# The Sizewell C Project

SZC Co.'s Response to the Secretary of State's Request for Further Information dated 31 March 2022: Appendix 8 - Additional technical information to support Question 8.11 in relation to Natural England, RSPB and SWT comments on assessment of coastal processes

## APPENDIX 8: ADDITIONAL TECHNICAL INFORMATION TO SUPPORT QUESTION 8.11 IN RELATION TO NATURAL ENGLAND, RSPB AND SWT COMMENTS ON ASSESSMENT OF COASTAL PROCESSES

TEMPORARY COASTAL DEFENCE FEATURE GENERAL ARRANGEMENT

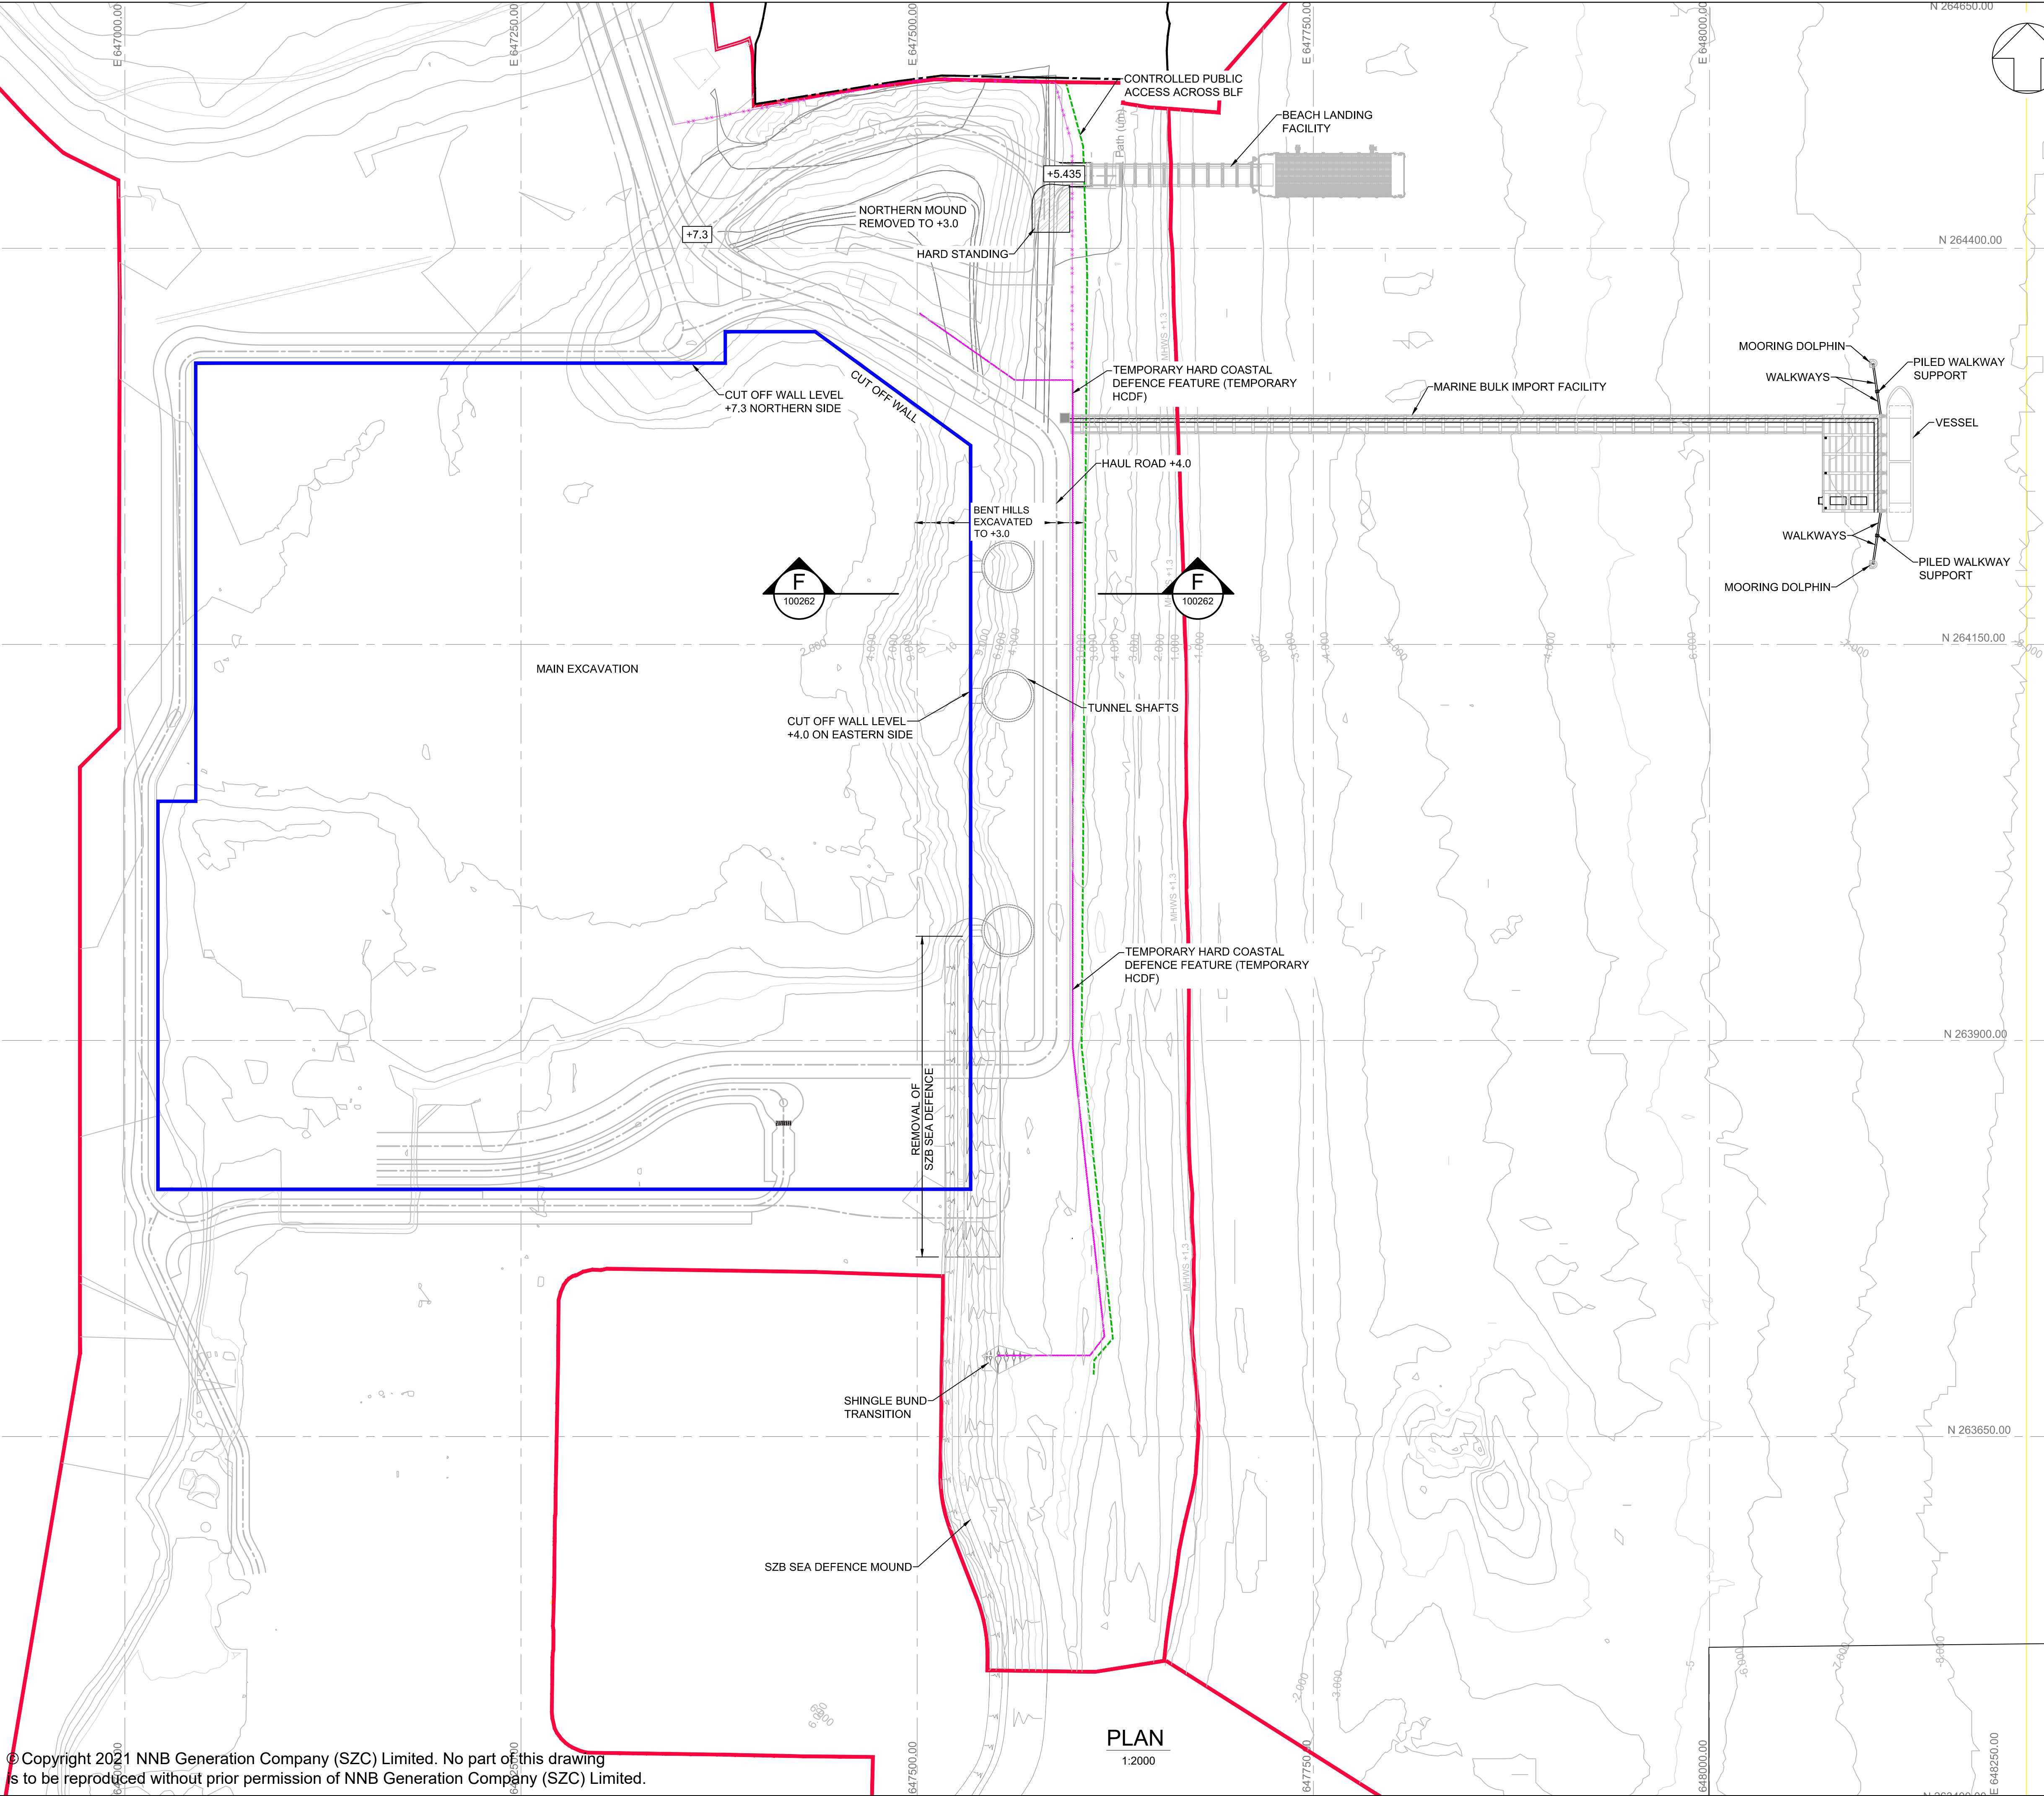
20.5 (Coastal Defences Design Report)	RSPB / SWT	Section 4.2.1 (epage 40) states that 'Access to the foreshore from the Main Construction Area, to install the Temporary Sea Defences, is likely to be created via a limited excavation at the western toe of the Northern Mound and work around to the east.' As per fig x above, the northeast corner of the northern mound is situated on RSPB Minsmere. We are not sure how it is anticipated that works access will be achieved without more substantial removal of the northern mound than is indicated here.

Ref	Who	Question / Answer
	SZC Co	<p>During the Construction Phase of the station the Northern Mound will be removed and replaced with an engineered embankment to become a classified sea defence structure. These works are shown within the Applicant's red line boundary and Land ownership in <i>Sizewell C Coastal Defences Design Report</i> [REP8-096]. Figure 41 indicates the extent of the mound removal and Appendix A-3: Figure 3-5 indicates the extent of the permanent sea defences.</p> <p>The proposed early works at the Northern Mound area will facilitate construction of the temporary sea defence and the BLF via a temporary access road. This temporary road will be contained within the red line boundary and will precede the main sea defence activity, intersecting the Northern mound at the +2 to +4m contour and limiting the need for extensive early excavation. This is shown indicatively on the attached markup of Figure 3-5. The haul road will be within the landscaped and footpath areas as these areas will be disturbed already.</p> <p>The low-lying area to the east of the Bent Hills area, outside of the areas claimed as sea defence by SZB, will also be levelled, generally around existing contours, to create an access for smaller plant and site access servicing the temporary sea defence construction.</p>
